WEST SUSSEX COUNTY COUNCIL CONSULTATION

TO:	Arun District Council FAO: Simon Davis
FROM:	Alison Meeus, Highways, WSCC
DATE:	12/06/2018
LOCATION:	Carlton Avenue, Rose Green, Bognor Regis Land to the rear of 34,36,38,40 and 44, Carlton Avenue, Aldwick
SUBJECT:	<u>AW-130-18</u> Outline Application with some matters reserved for the erection of 8 no. dwellings with new access between 34 and 36 Carlton Avenue.
DATE OF SITE VISIT:	n/a
RECOMMENDATION:	☒ Advice ☐ Objection ☐ Modification ☒ No Objection ☒ More Information ☐ Refusal
S106 CONTRIBUTION TOTAL:	£ See below for breakdown.

SWEPT PATH ANALYSIS USING A
LARGE 3 AXLE REFUSE VEHICLE

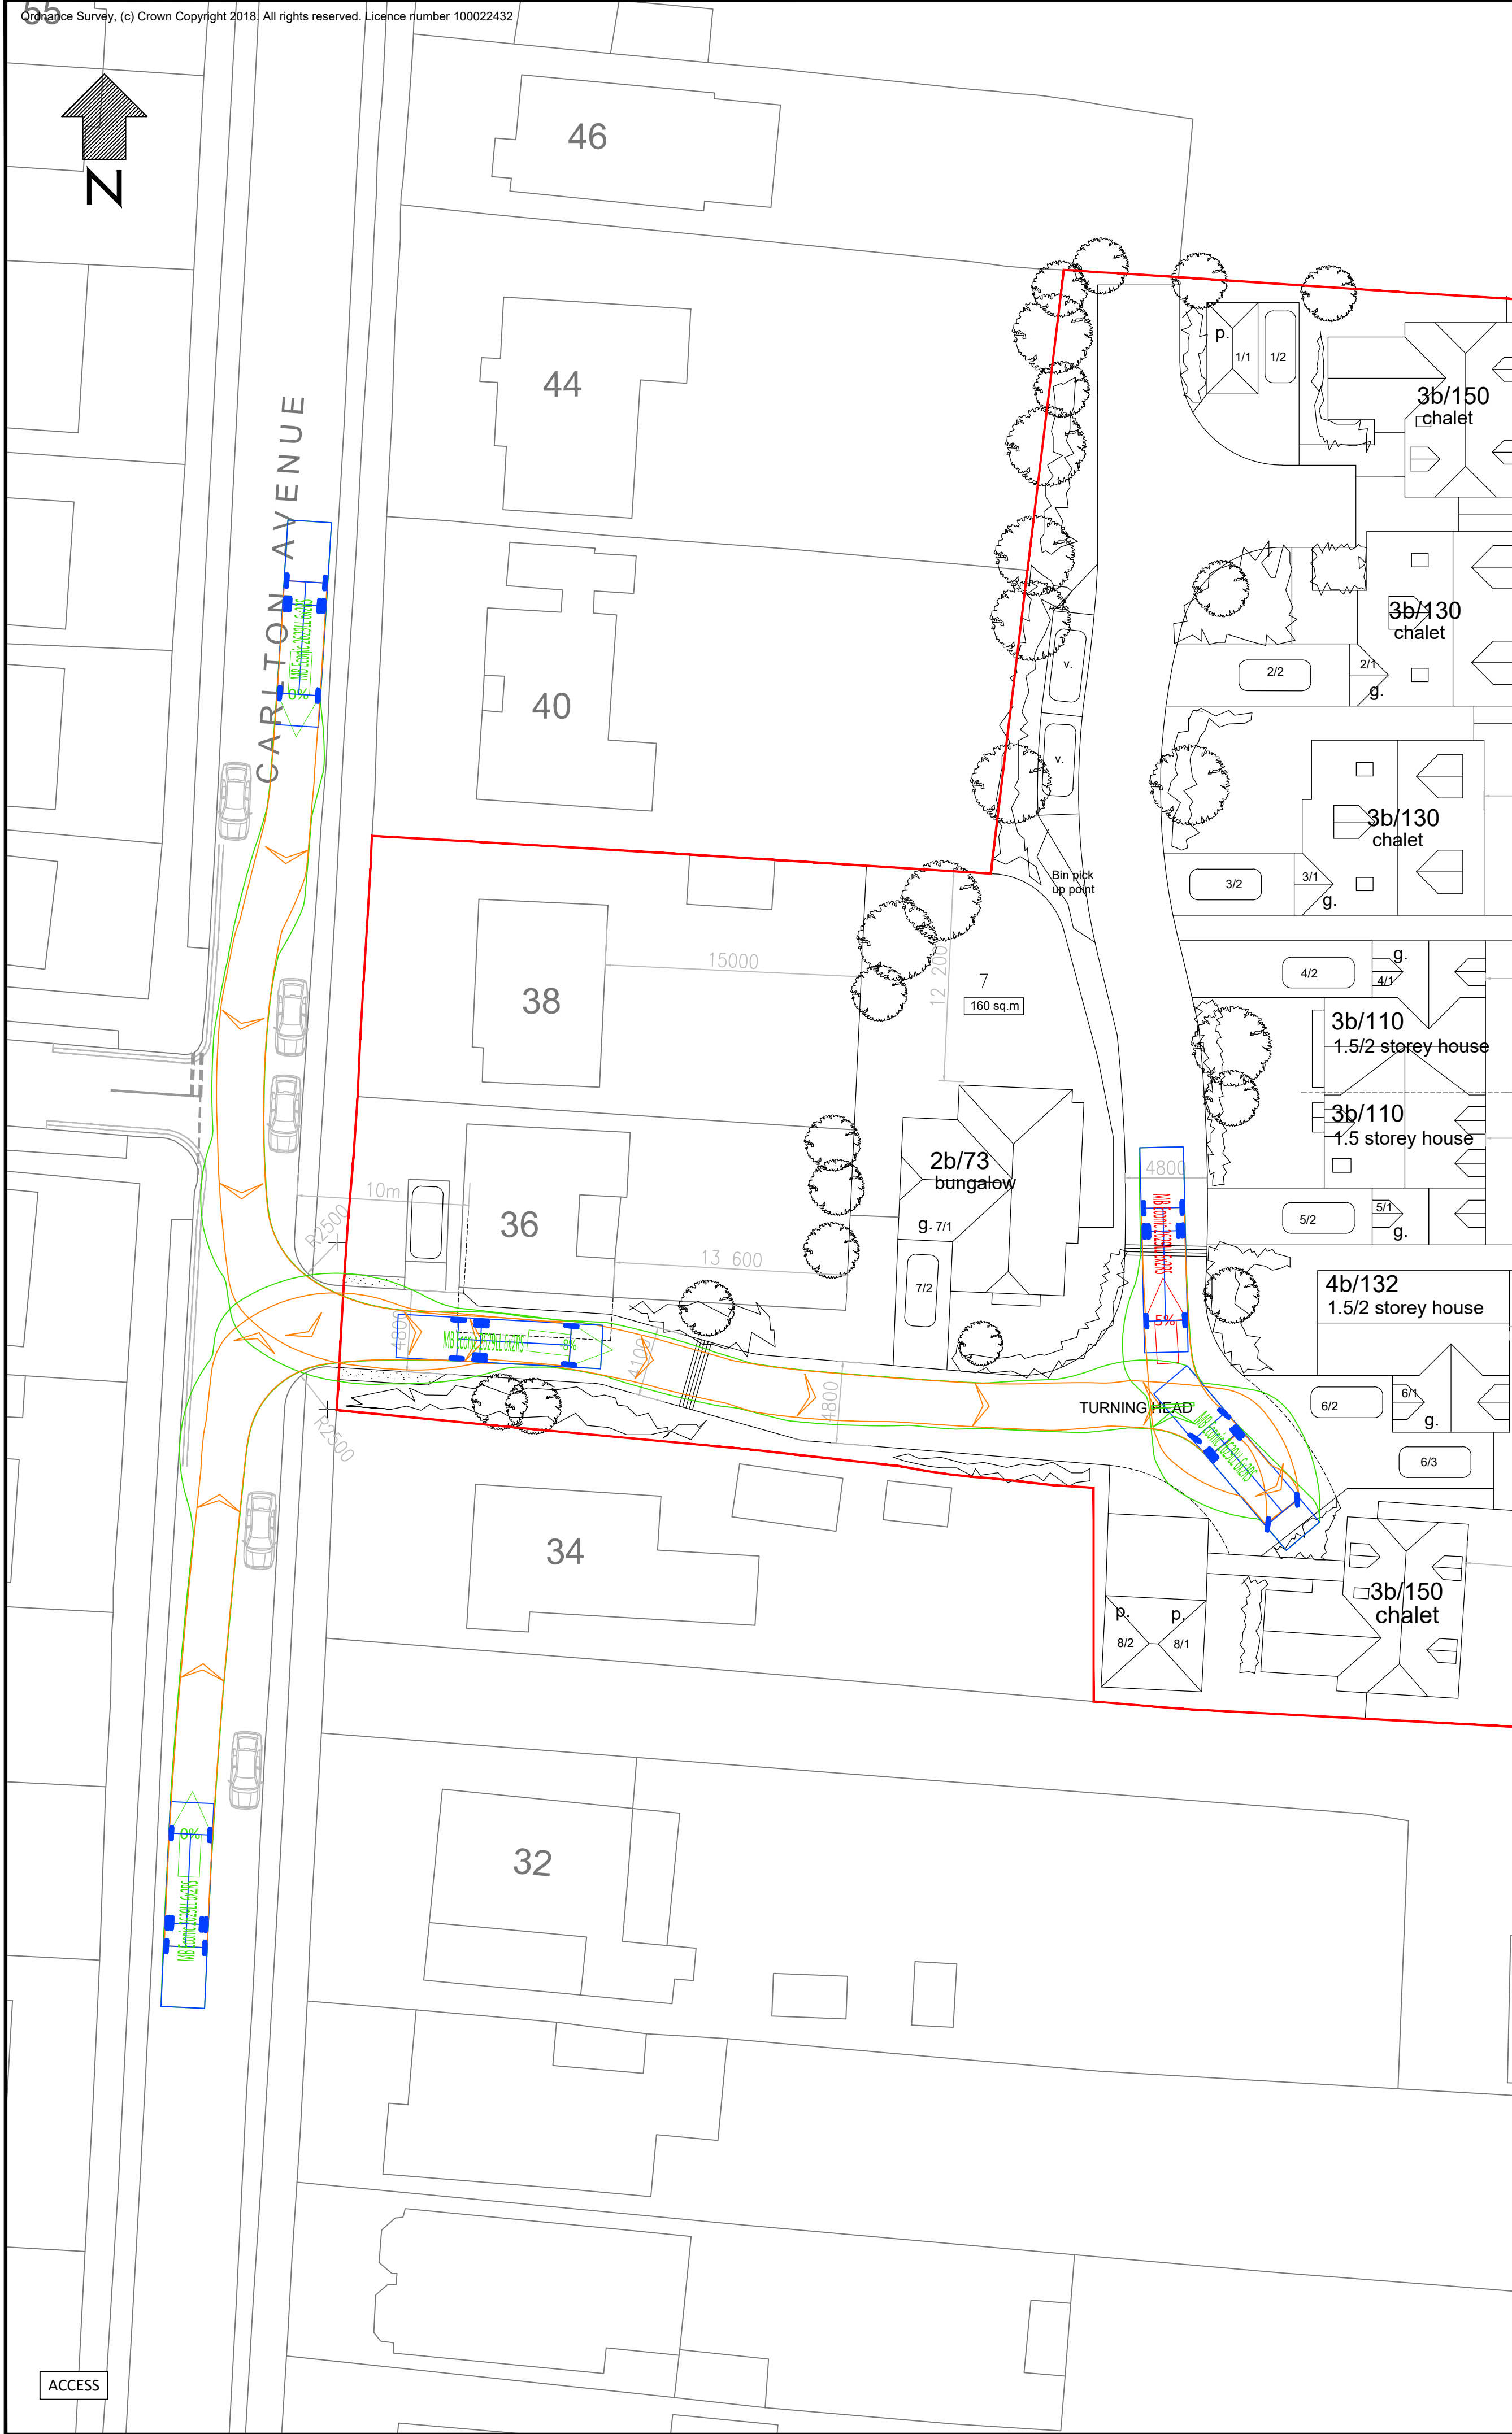
However no swept paths have been provided and WSCC are concerned about the turning movement of a large appliance into and out of the access from Carlton Avenue due to parked cars. Please provide these.

- Swept paths showing the turning movement of a large appliance into and out of the access from Carlton Avenue with parked cars on the road.
- Swept path showing use of turning head by large appliance or dimensions to prove enough space is provided.
